Our ref: DOC21/318072  
Senders ref: SSD 10479

**Response to Submissions – 200 Aldington Road Industrial Estate (SSD-10479) - additional waterway health comments**

I refer to your email of 26 March 2021, requesting input from Environment, Energy and Science Group (EES) in the Department of Planning, Industry and Environment (DPIE) on the Response to Submission (RtS) for 200 Aldington Road Industrial Estate (SSD-10479).

**Figure 3 – Stage 1 Works Plan.**

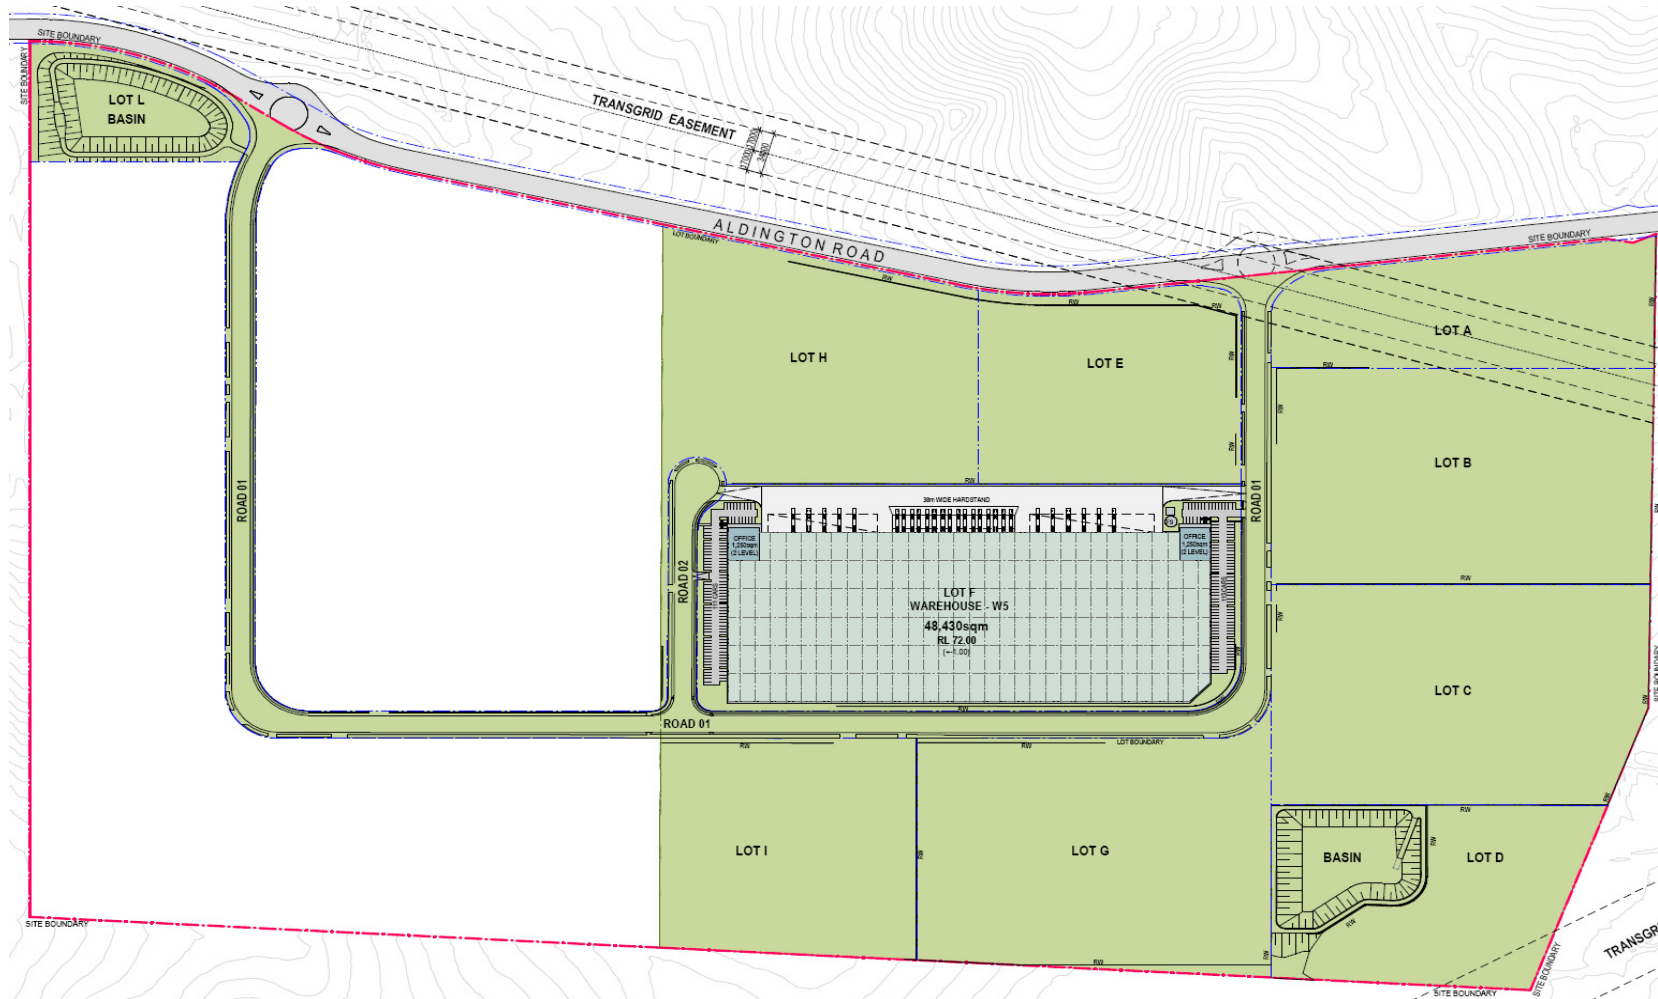
The proposed condition of consent outlined by the applicant in the RtS report is not reflected in the concept plans at Appendix C. The extent of WSUD infrastructure shown on Lot L in both the Stage 1 Works Plan and the SSDA Estate Master Plan (see pp 5-6, Appendix C) is the same i.e. there has been no change in the extent and type of WSUD infrastructure in the final master plan to show how the cumulative impacts of the development are mitigated/managed to achieve the target. It is therefore strongly recommended, prior to determination, that the applicant provide a concept plan to demonstrate the location and type of WSUD infrastructure that will address the cumulative impacts.
